20160619.3/2003A/R0/JS

20/03/2018

**Darlington Terraces Student Accommodation - Response to Department of Planning Test of Adequacy**

Figure 1: Site Survey and Monitoring Positions

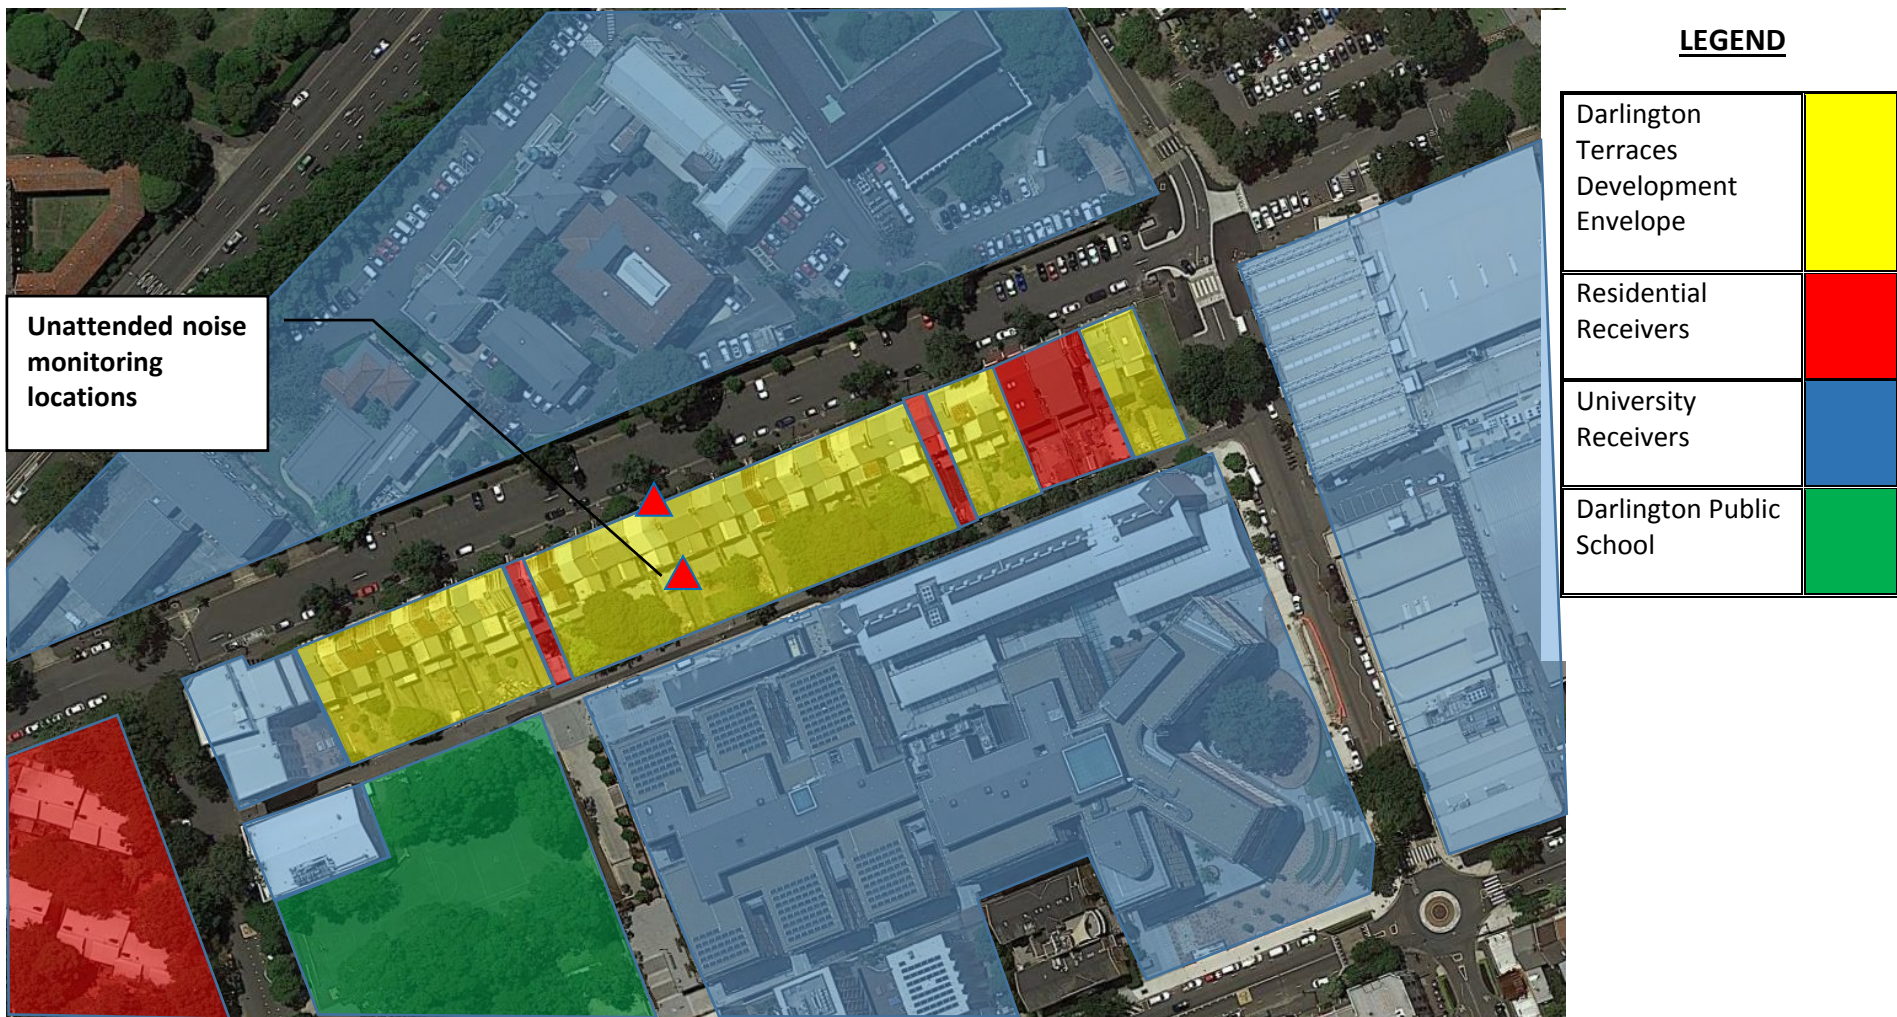
*Appendix AA Noise Impact Assessment – the unattended long-term noise monitoring used to determine rating background levels does not appear to have been carried out in accordance with the guidance material outlined in the NSW Industrial Noise Policy (INP). Data loggers are required to be placed at the most (or potentially most-affected) noise-sensitive locations (refer Appendix B of the INP). Compliance with this requirement of the INP is consistently being requested by the Environment Protection Authority in its submissions on SSD applications. Unattended data loggers should be positioned at the nearest residential receivers (not owned by the University) and Darlington Public School.*

- Locating noise loggers at receiver locations was deemed impractical for the following reasons:
  - The noise logger would be located in close proximity to the tenants of the receiver properties. In this regard, tenant noise would likely have impact on the noise monitoring (i.e. television, music, conversational noise).
  - University owned terraces adjacent to the receivers were also occupied and as such these monitoring locations would also be susceptible to tenant noise.
- The terraces used for the monitoring were vacant and as such potential tenant noise impacts on the noise monitor would be non-existent.

Pursuant to the INP, the noise monitoring location was deemed representative of the receiver location given receivers and the monitoring position were:

- significantly screened from noise along City Road,
- experience direct noise from Darlington Road, and
- are exposed to noise from University of Sydney buildings along the Southern boundary.

Whilst the noise monitors were not located directly at receiver locations, the chosen monitoring positions are considered representative of the acoustic environment experienced at receiver locations and as such is acceptable under the INP.

Noise impacts to Darlington School would be assessed against the internal noise requirement of 35dB(A) for 'School Classroom'. On this basis, no monitoring would be required.
